**Subject:** Fwd: FW: 22995 - Manor Nursery A/86/20/DOC - Designer Response

Condition 21- surface water drainage design

CLIENT	Roffey Homes Ltd		
PROJECT	Manor Nurseries Site Angmering		
TITLE	Proposed Drainage Strategy		
DRAWN	DATE	PROJECT NO.	
T Zajac	Mar 2018	22995	
ENGINEER	CHECKED	DWG NO.	REV.
S Magowan		102	B
SCALE	1:250 @ A1

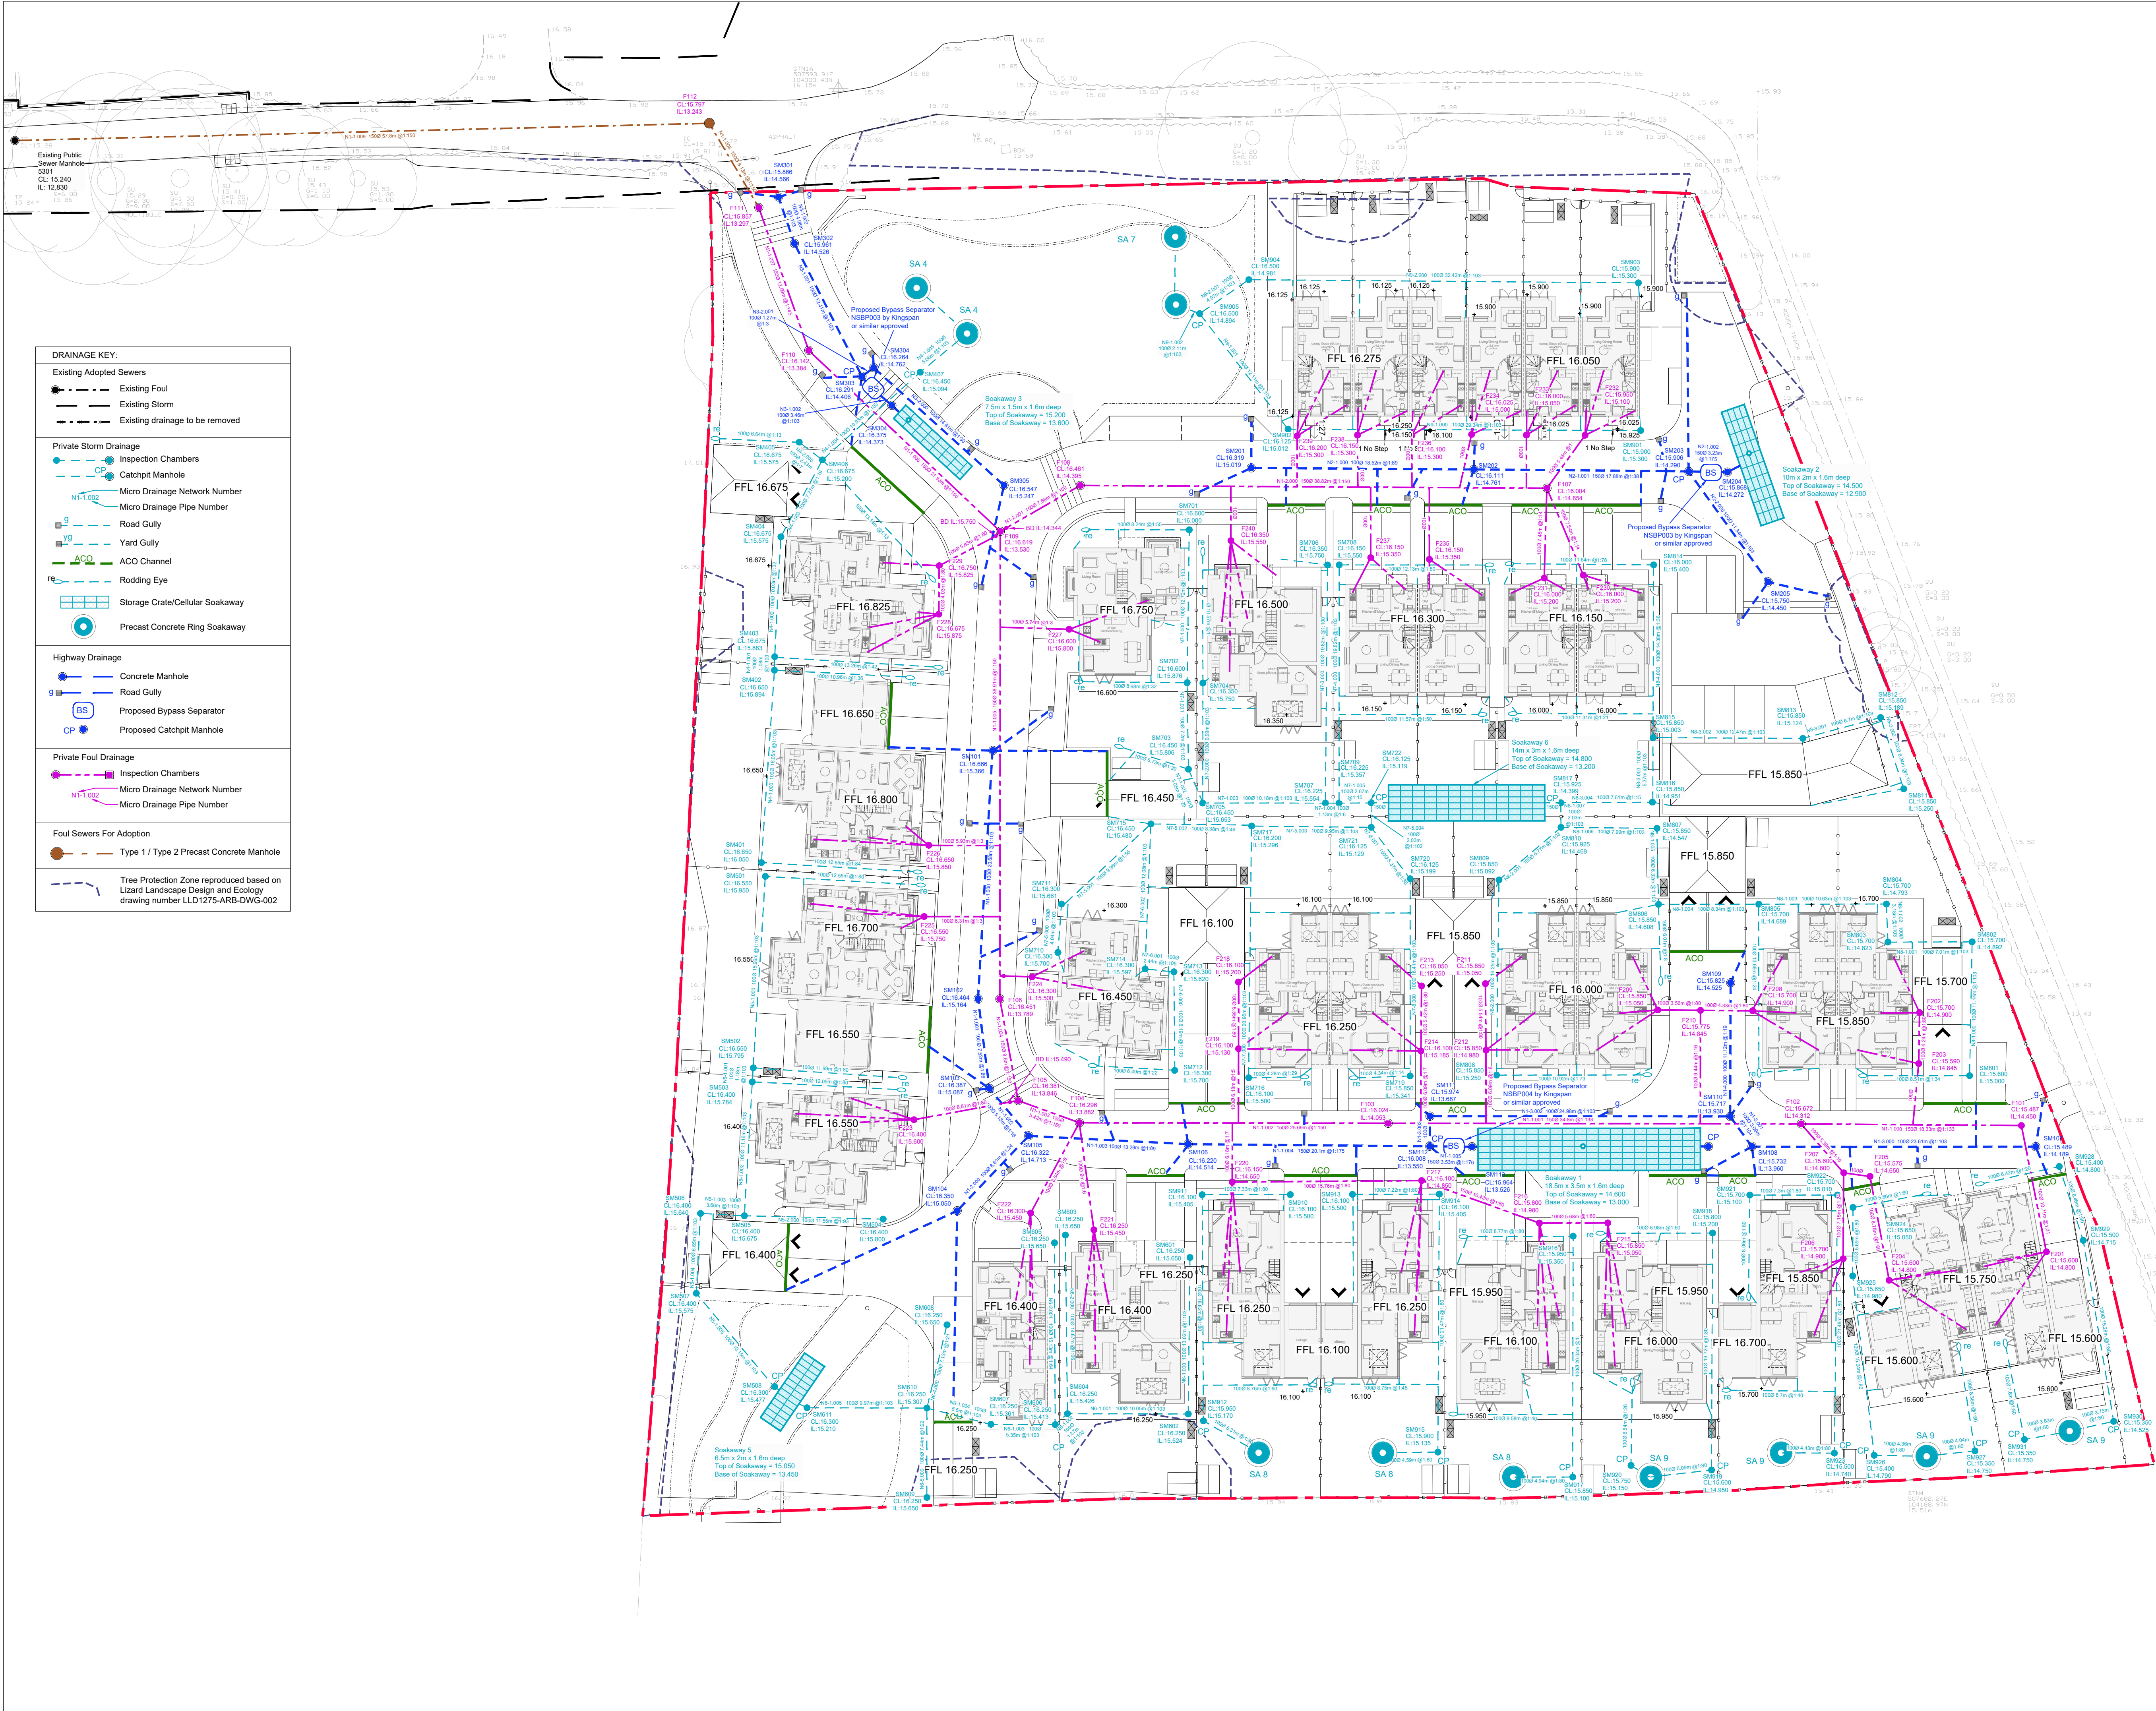
## 3. All infiltration tests were undertaken at circa 2.5m depth, yet some of the soakaways are considerably shallower than this.

The design notes only two soakaway designs with the base shallower than 2.5m bgl. These are SA8 and SA9 and both are located within the gardens of the properties along the southern boundary of the site. Soakage testing was undertaken at a depth of 2.5m within the gravel strata below the site. The trial pit logs within this area, TP1, TP2 and TP3, confirm the gravel strata is located at between 2.1 and 2.2m below ground and extends to the base of the trial pits. SA8 and SA9 soakaways are situated within this gravel strata. We therefore request this objection is removed based on the designed soakaways' depth extending into the tested soil strata where they will have the same performance as the tests. We have attached the Trial Pit data and location plan. Acknowledged that the same strata does just about extend to base, however ring soakaways are proposed which rely upon sides for infiltration only therefore they will not be utilising this

*gravel strata. We would recommend that these soakaways are made deeper to extend further into the gravel strata, but the base must be kept above peak groundwater levels/ base of monitoring wells.*

*We will require further information on how adequate treatment of surface water is occurring prior to discharge to ground in accordance with chapter 26 of CIRIA C753. There is no evidence of any pollution mitigation prior to discharge to soakaways. This is a particular concern regarding water from highways where pollution hazard indices are higher.*
